TfNSW Reference: SYD20/00719/02 (A36762396)

DPIE Reference: SSD-10473

**MARIST CATHOLIC COLLEGE NORTH SHORE MASTERPLAN – 264 AND 270 MILLER STREET, NORTH SYDNEY**

TfNSW has reviewed the submitted application and requests the following additional information for further assessment:

Figure 10 – Proposed bike parking locations at basement level

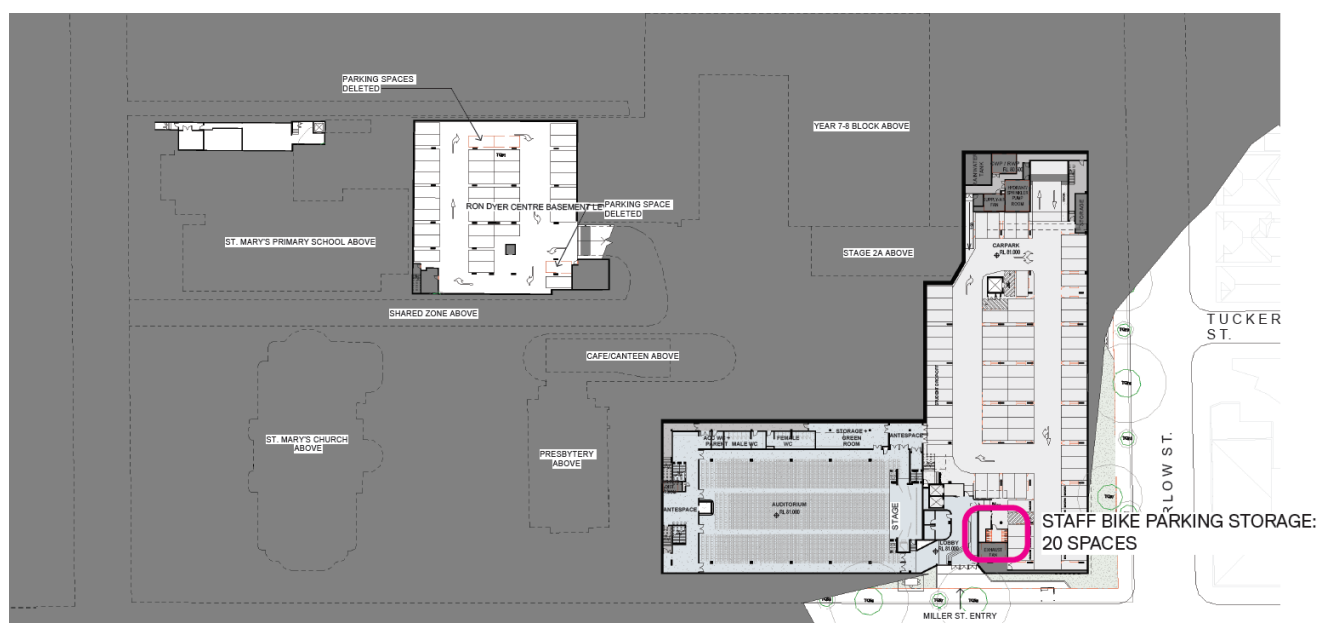
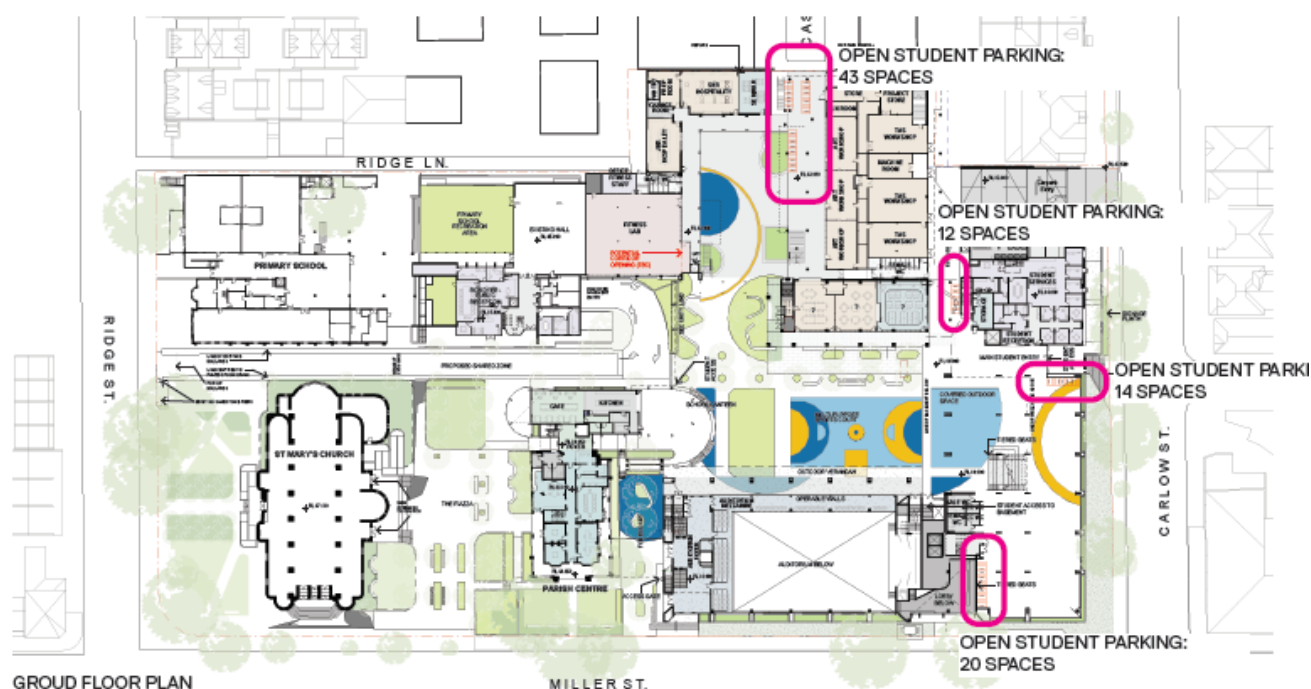
Bicycle parking for staff should be increased to 10% of proposed staff population to encourage non-car mode share for travel to and from the site, with adequate end of trip facilities also provided. Bicycle parking for primary school students should be provided to support primary school student cycle mode share (3% existing) for the proposed primary school student population

- 89 bicycle parking spaces for students and 20 bicycle spaces for staff. Locate bicycle parking and storage facilities in secure, convenient, accessible areas close to the main entries incorporating adequate lighting and passive surveillance and in accordance with Austroads guidelines.
